## Northwood Road Academy, Hillingdon

### GLA Response 1

Revision: P01

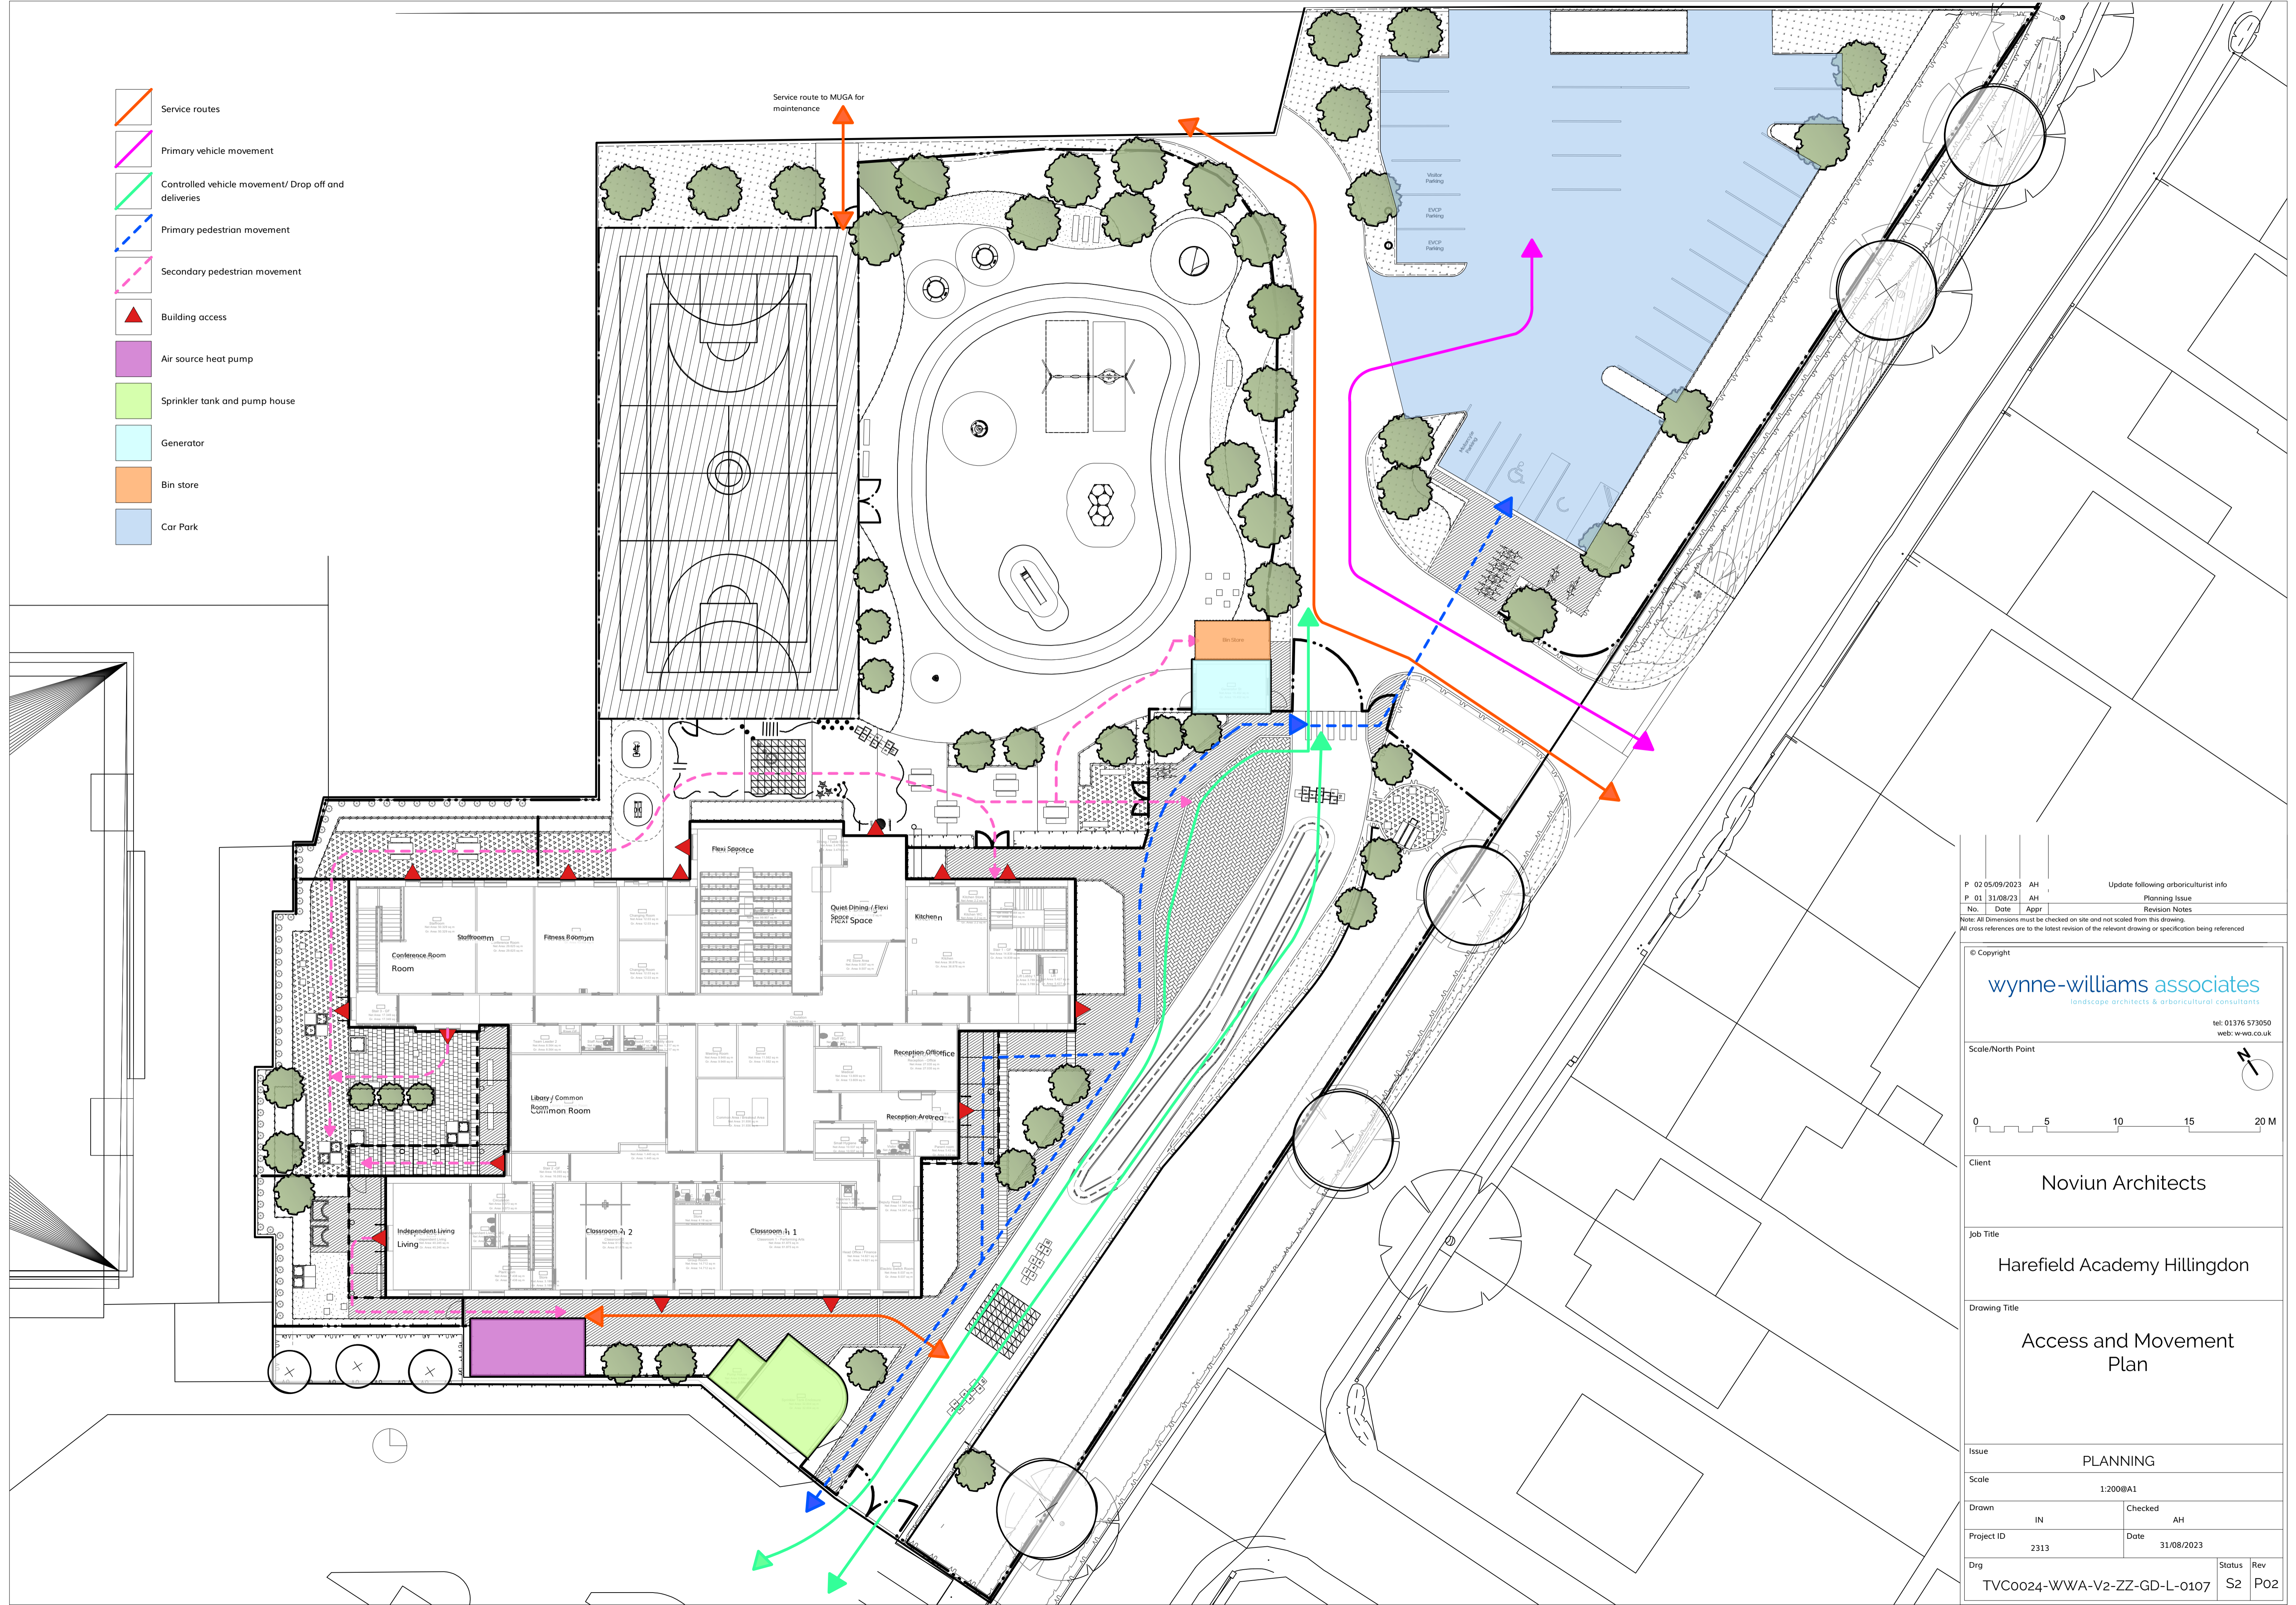
*40. Several utility structures, such as bin storage, water tanks and heat pumps, are proposed in standalone structures scattered across the site, in particular along the southern site boundary. This could create a cluttered appearance of the open space around the building, and in particular when viewed from outside the red line boundary. The applicant should seek to minimise the amount of standalone utilitarian structures by consolidating them within one single purpose-designed structure and provide adequate visual shielding where necessary through appropriate design and landscaping measures.*

Due to the available infrastructure on the site and existing services points the utilitarian structures are placed in different locations to accommodate the needs of the new building. The positioning of the structures was meticulously thought out to minimize the impact that will have on the outdoor space available for the pupils. The school preference was to keep away the ancillary structures from the main play area and to limit the potential distractions during services time that may cause behavioural issues. These structures are usually timber fenced but in this instance the sprinkler tank is proposed as a brick enclosure that gives the opportunity to be used for school signage. The use of the architectural language to create a cohesive approach across the site.

Due to the site constraints, it was considered that the Air source heat pump and Sprinkler tank enclosure is best to be positioned on the southern elevation towards the car park having access to the plant rooms adjacent. These standalone structures help with creating a more defined boundary between the existing car park and the new building.

The electrical switch room has been located on the East corner of the building to allow easy access for servicing and being adjacent to the sprinkler tank enclosure.

The bin store enclosure is positioned outside of the secure line with easy access from Northwood Road.
